**Consultation Response from KC,
Highways Development Management**

2024/90078 58, Southfield Road, Waterloo, Huddersfield, HD5 8RJ

Erection of 1800mm high close boarded boundary fence

Date Responded: 12/03/2024.

EXISTING AND PROPOSED SITE
PLANS. NEW 1800MM HIGH FENCE

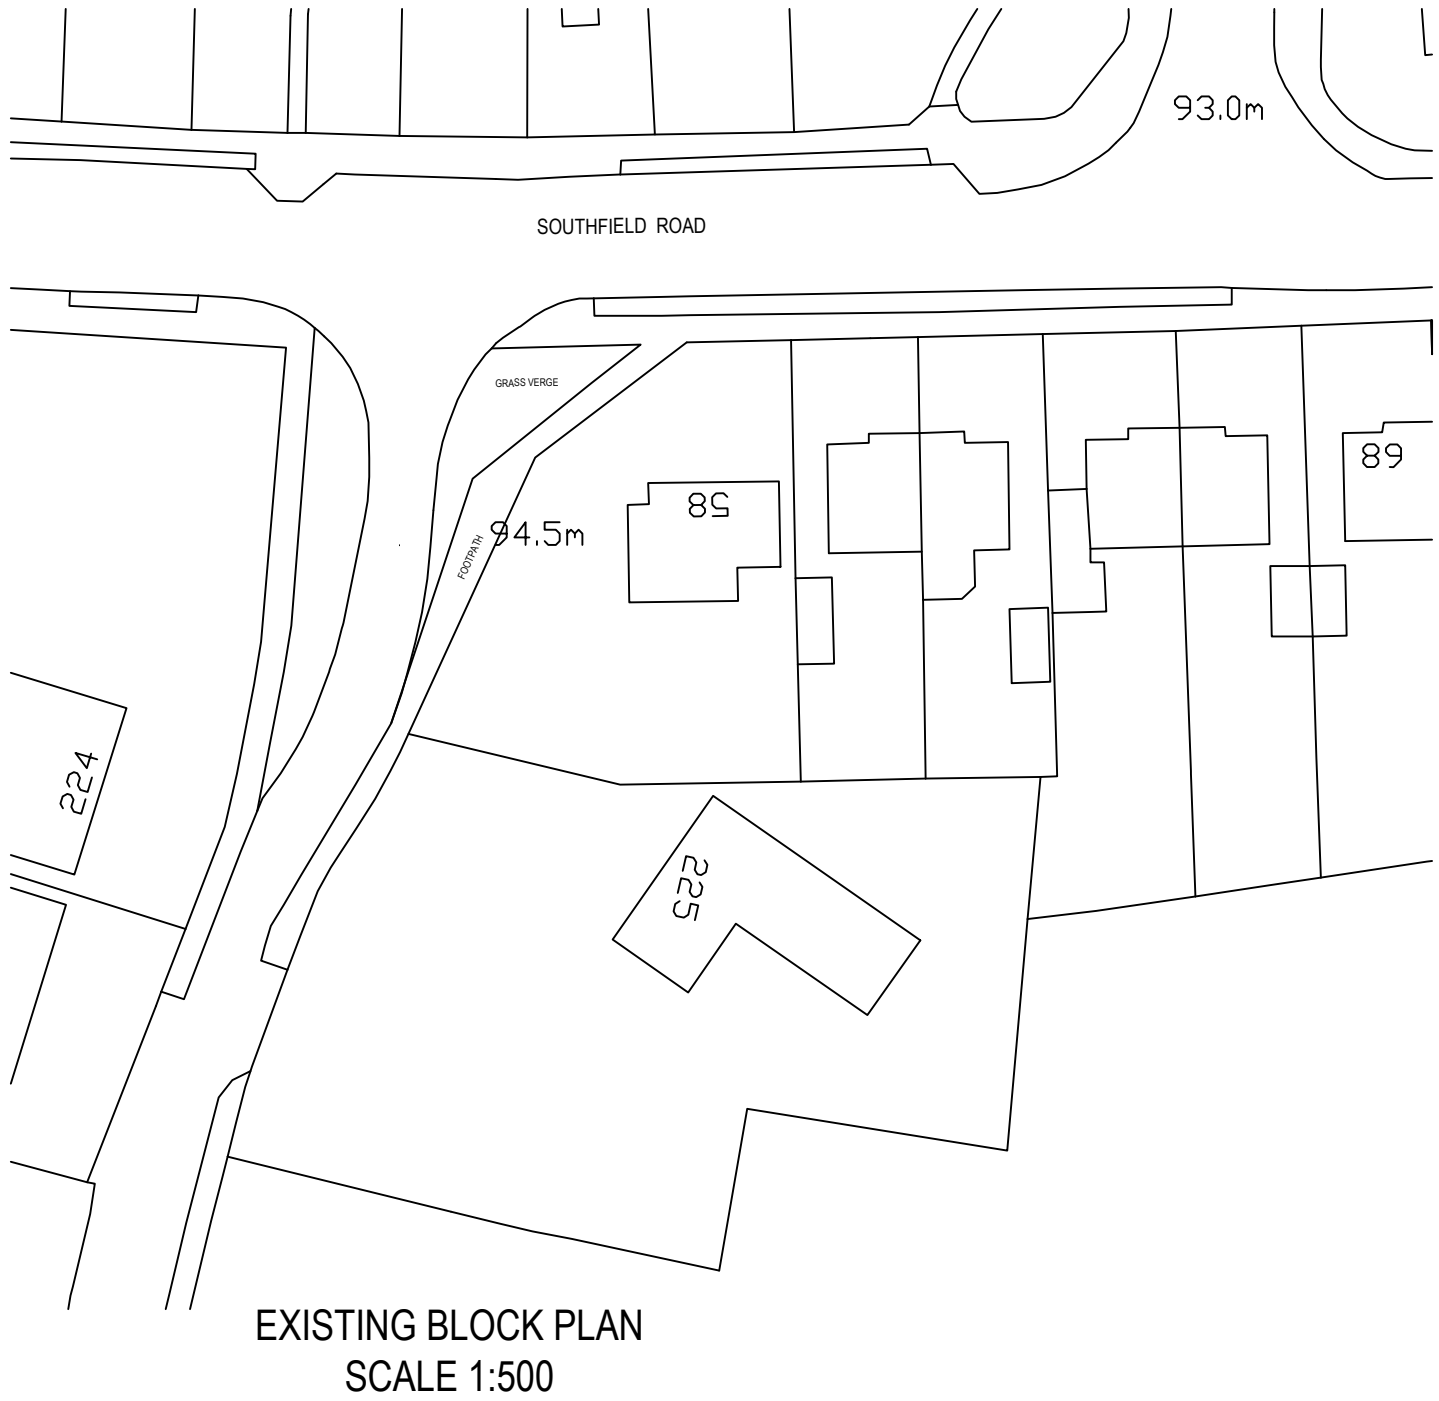
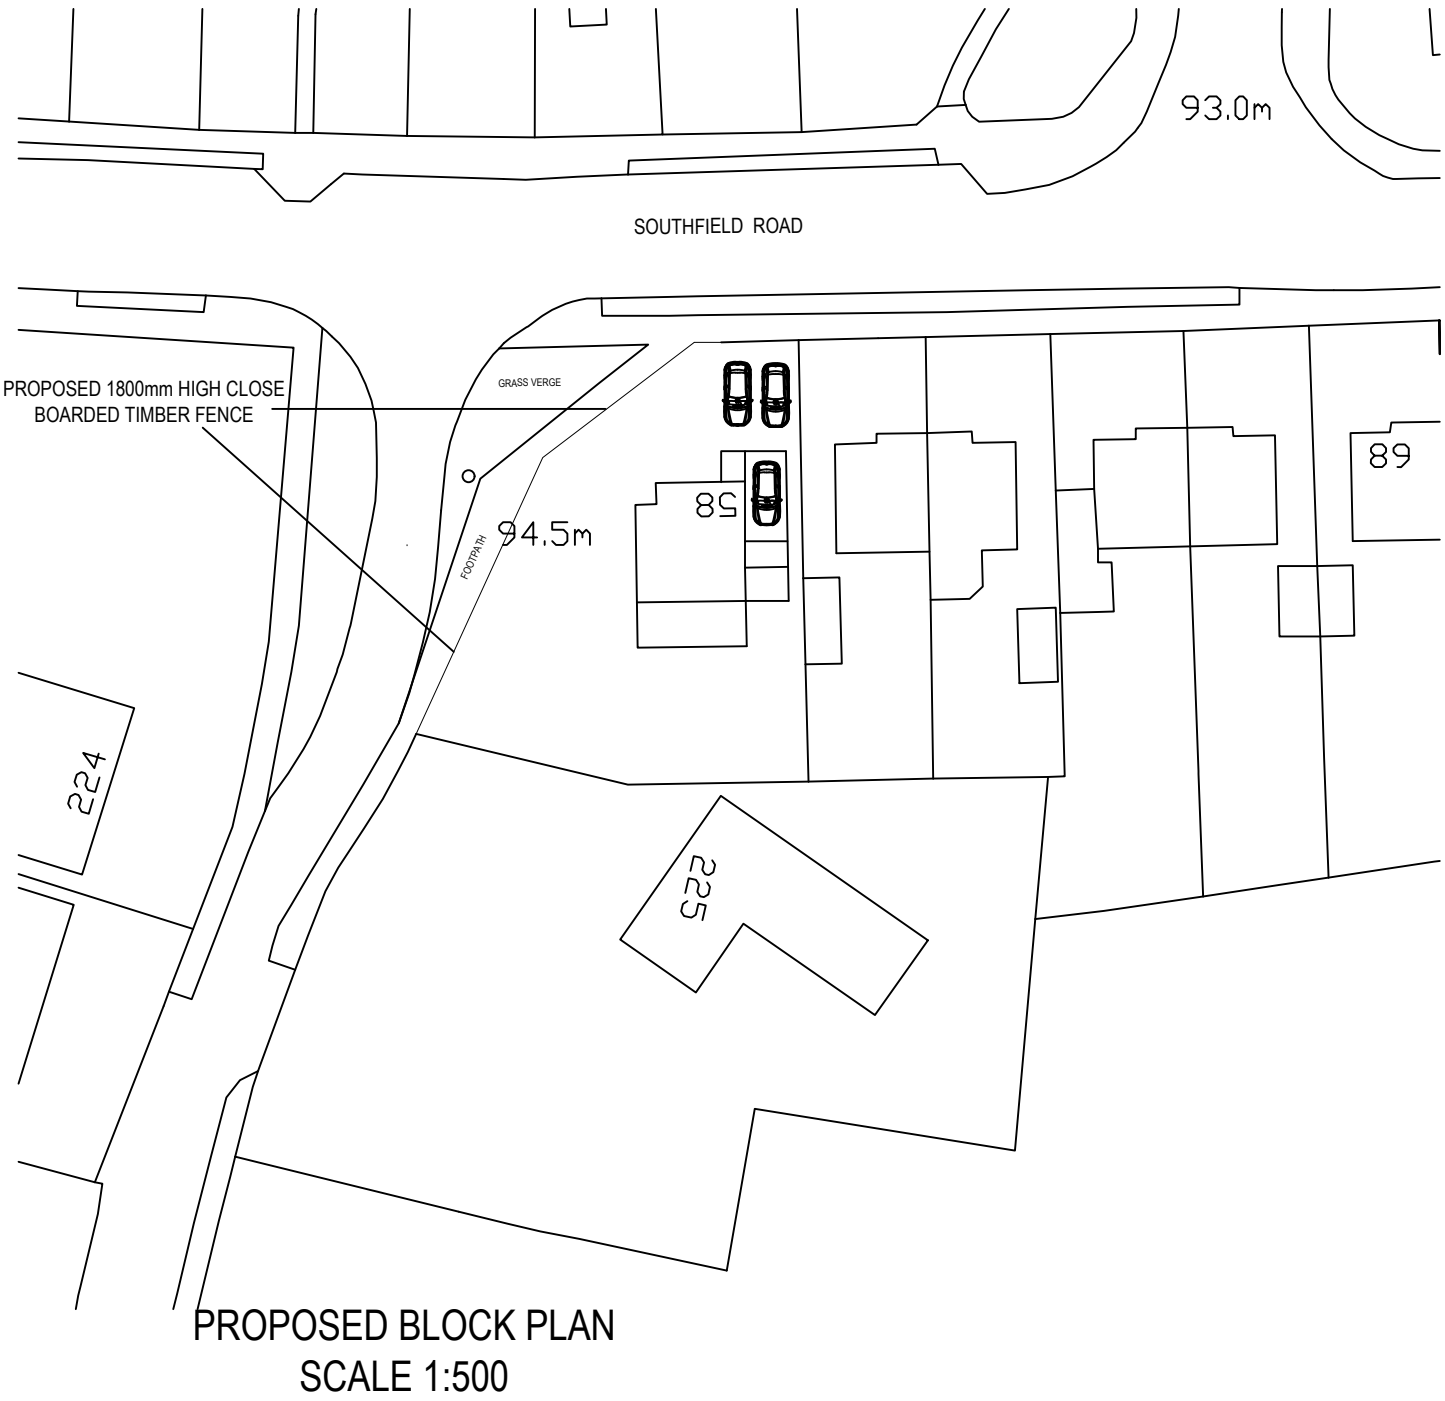
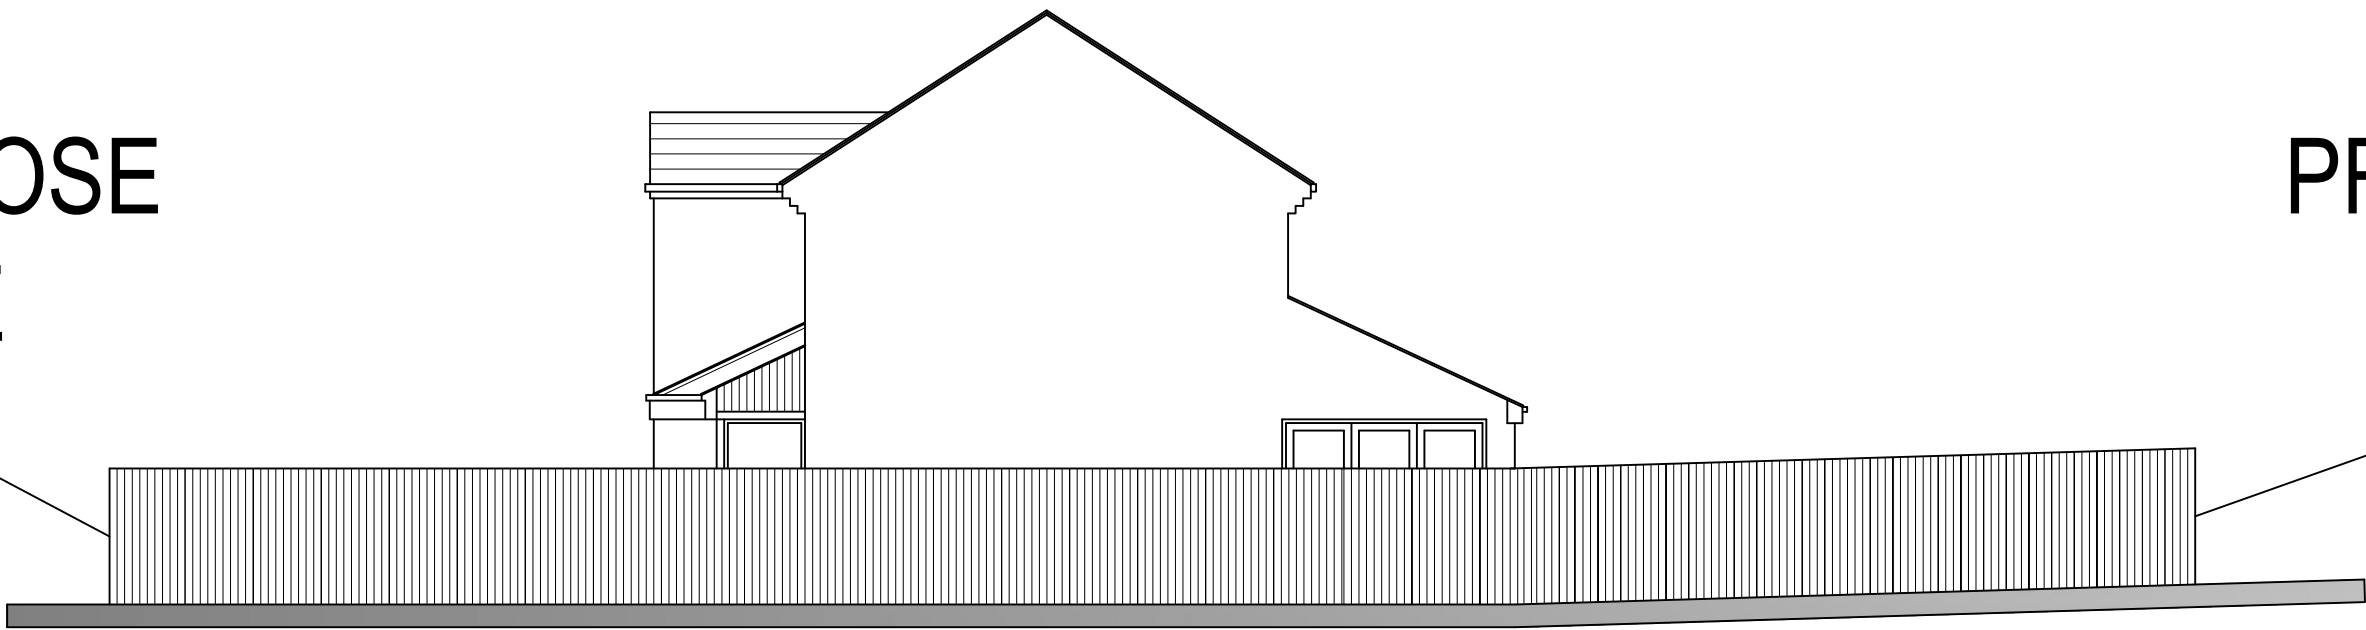
The fence is set back so that the recommended visibility splays of 2.4m x 43m at the adjacent junction of Fleminghouse Lane with Southfield Road have been maintained.

As a result, the proposed fence does not affect the existing sight lines.
